From: Beverly Appleyard [REDACTED]
Sent: 12 September 2019 14:44
To: Simon Davis
Subject: Planning Application AW/237/19/PL

Dear Mr Davis,

VEHICLE TRACKING PLAN

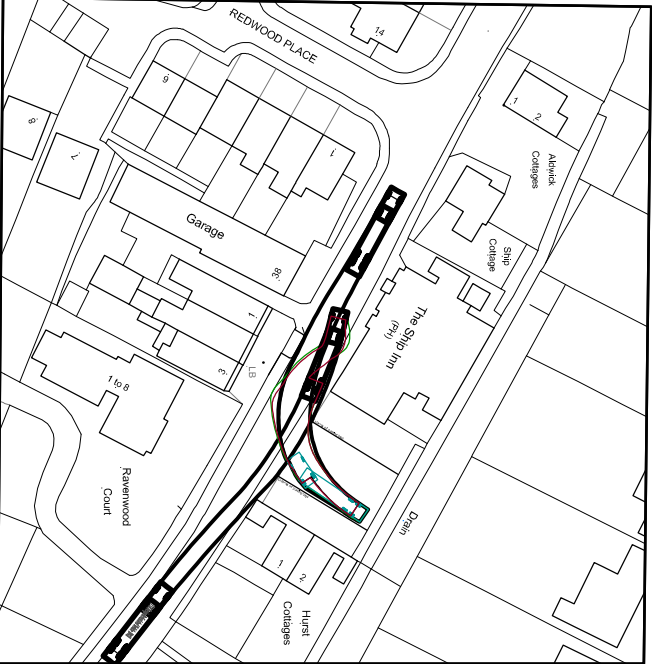
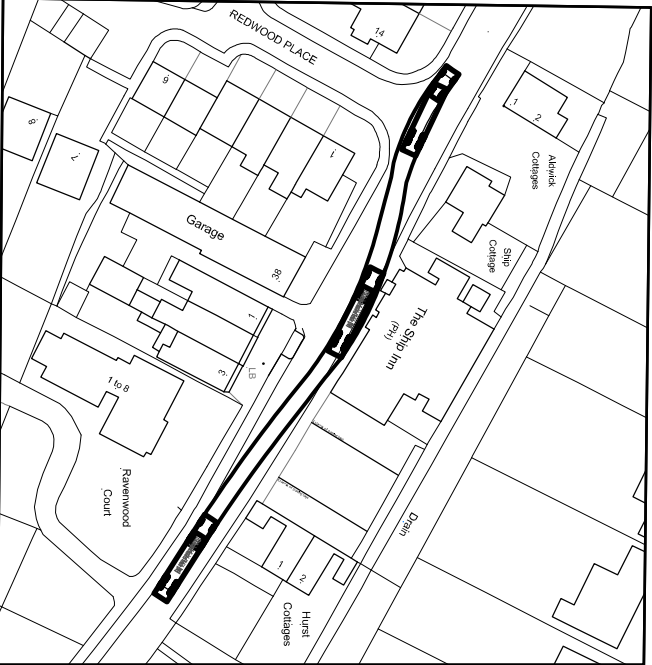
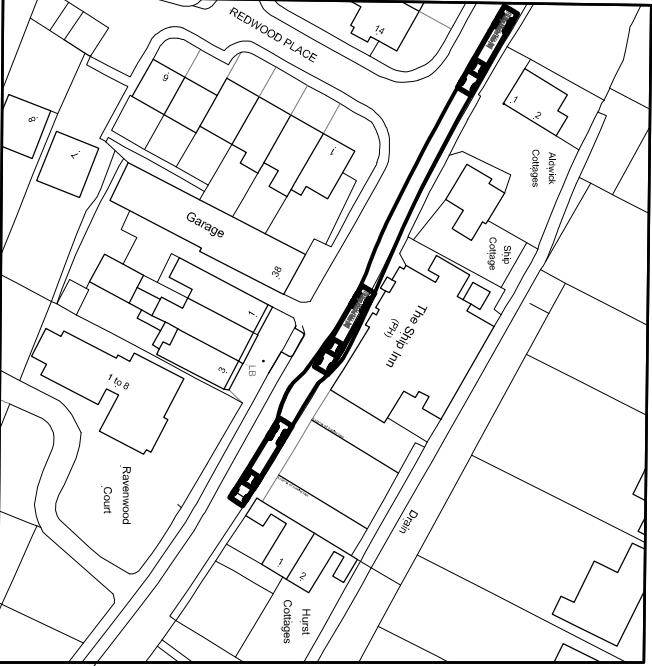
I have looked at the delivery schedule/arrangements and it is clear that these will be a considerable nuisance to local people. Its hard to imagine how a 38ft, 28-tonne articulated truck will be able to negotiate deliveries without serious health and safety issues, 4 times a week. Add to this the 4 deliveries by 3.5 Tonne box van, 3 deliveries by 18 Tonne rigid vehicles, 5 deliveries by 26 Tonne refrigerated vehicles, 12 deliveries by 18 Tonne rigid vehicles and 7 transit vans each week and I'm sure you'll agree that things would be very miserable for local residents. Their health, safety and well being will be considerably challenged. It's also worth noting that the estimated 35 delivery slots per week is considerably greater than the three deliveries a day (21 per week) that Morrison's had permission for.
